Historic England

6 July 2023

**PRICKLEDEN MILLS, WOODHEAD ROAD, HOLMFIRTH, HUDDERSFIELD, WEST  
YORKSHIRE HD9 2JU**

**Application No. 2023/91491**

**PROPOSED SITE PLAN**

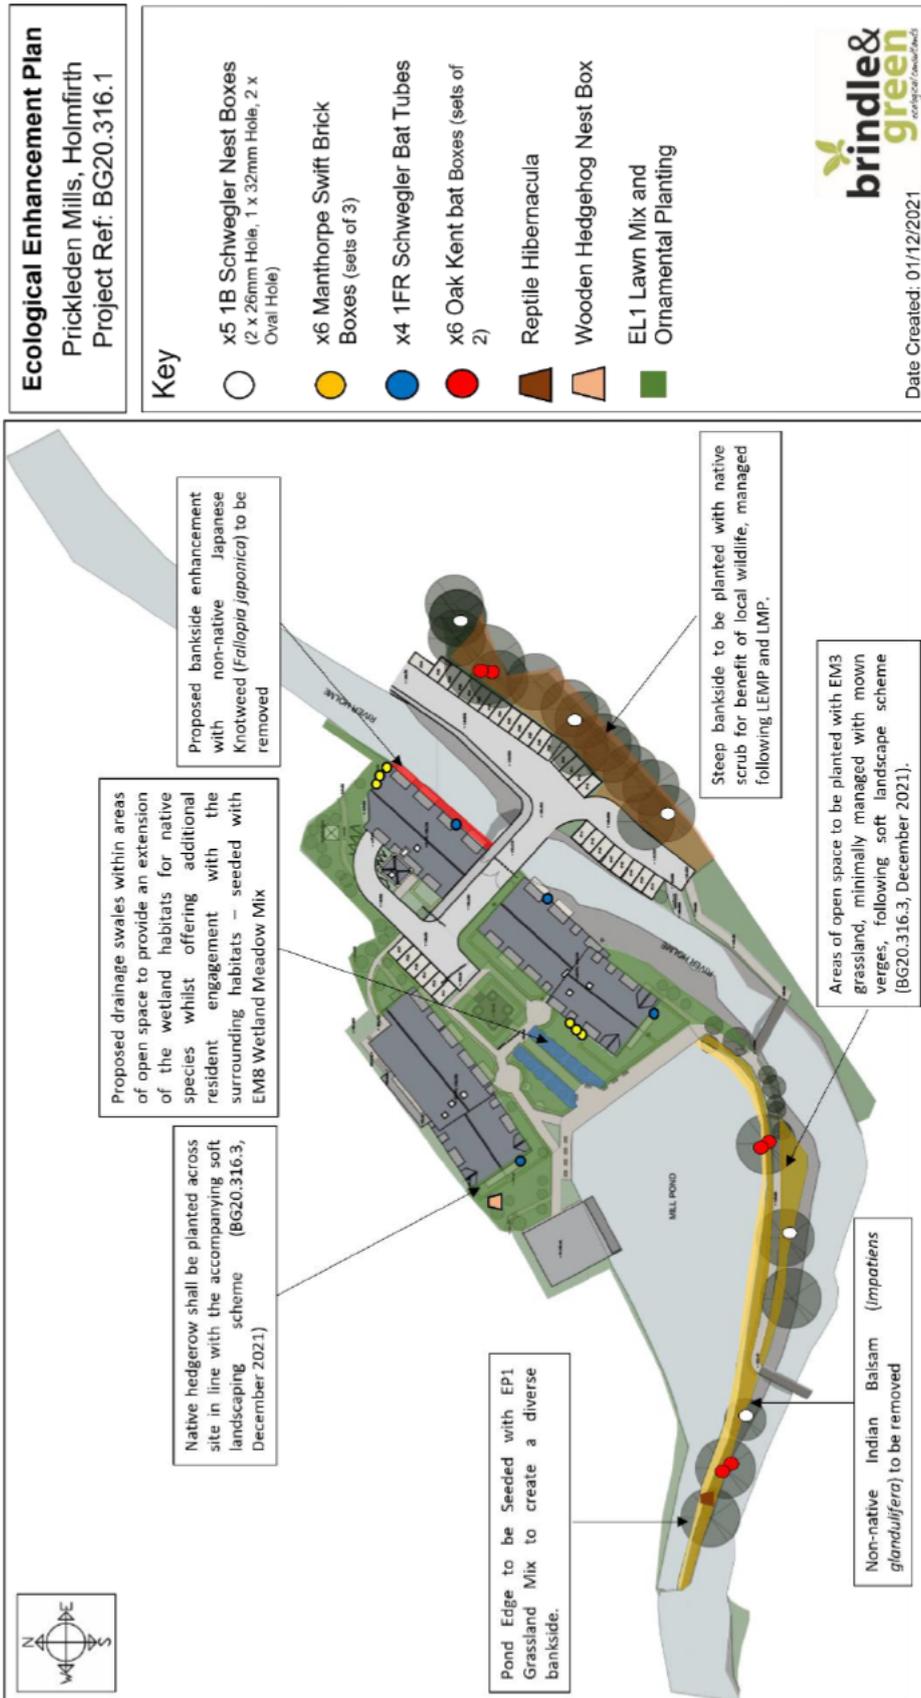
The current application has a footprint and layout more similar to the consented proposals. The lowering in ridge heights and adjustments to the scale and massing of buildings C and D reduce the level of harm arising from the proposal, but they do not eliminate it.

We would encourage the applicant to continue to refine the relationship between buildings C and D and the domestic-scale properties on Woodhead Road, including a pair of Grade II listed cottages. We would also encourage the applicant to work further with your authority to ensure that all opportunities to create a scheme which celebrates the historical character of the wider site are taken.

In addition, the architectural language of the revised proposal and some of the more strident features, such as projecting balconies, also require further refinement. Such features increase the visual impact in what is a largely homogenous and organic townscape. Again, we would encourage the applicant to work further with your authority and achieve a balance between historic references and contemporary styling which sits more comfortably within the existing topography and townscape.
